March 26, 2020

Re: The Shire at Old Ranch
Traffic Study Deviation Letter
El Paso County, Colorado

Sight Distances

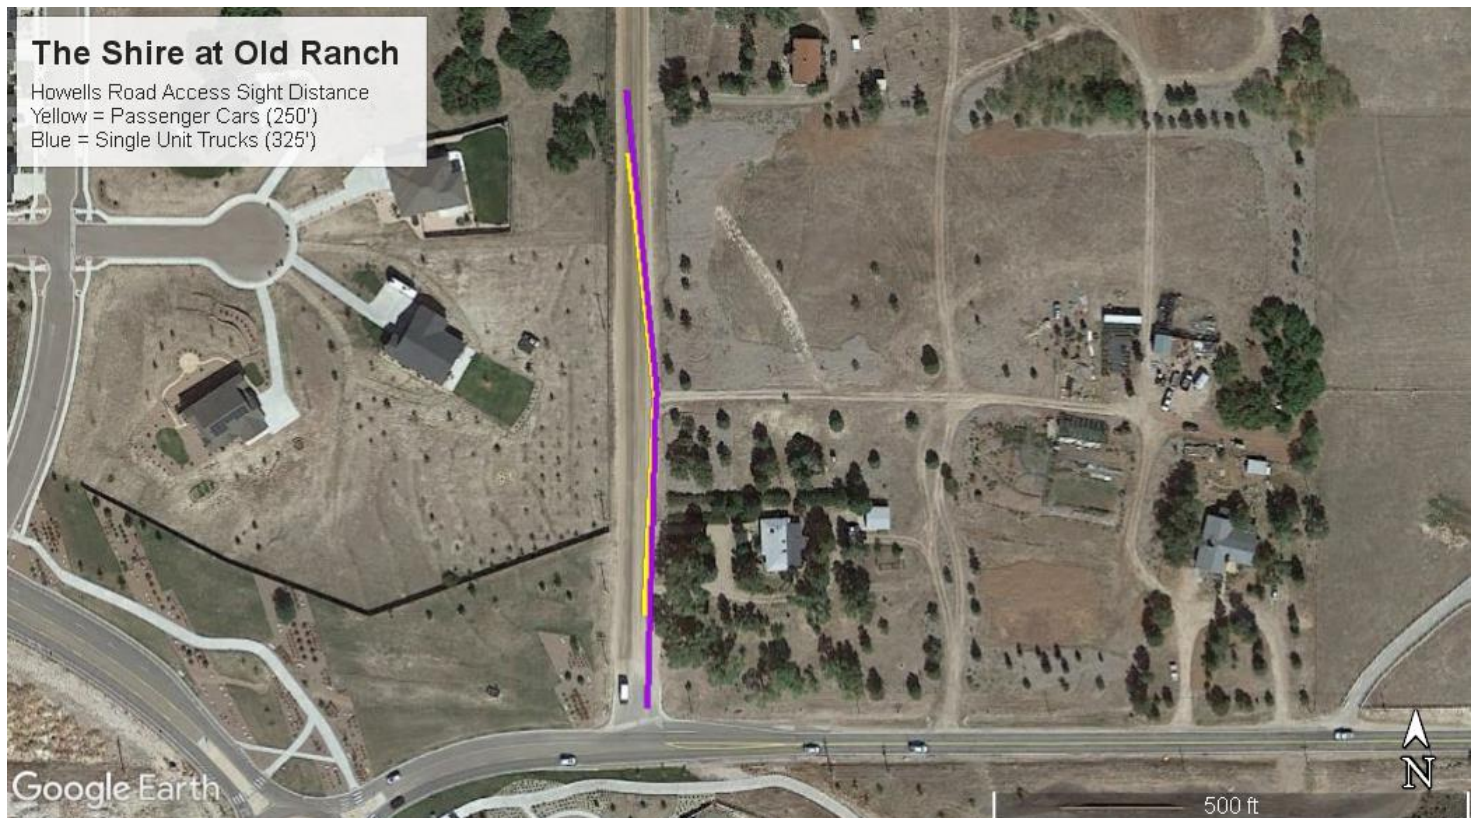
Revise. The access sight distance is for both approaches (looking left and right at the access point).

update. The referenced table is for intersection grades.

provide an exhibit showing the sight triangles.

Revise. The traffic study needs to validate the the proposed access meets county criteria.
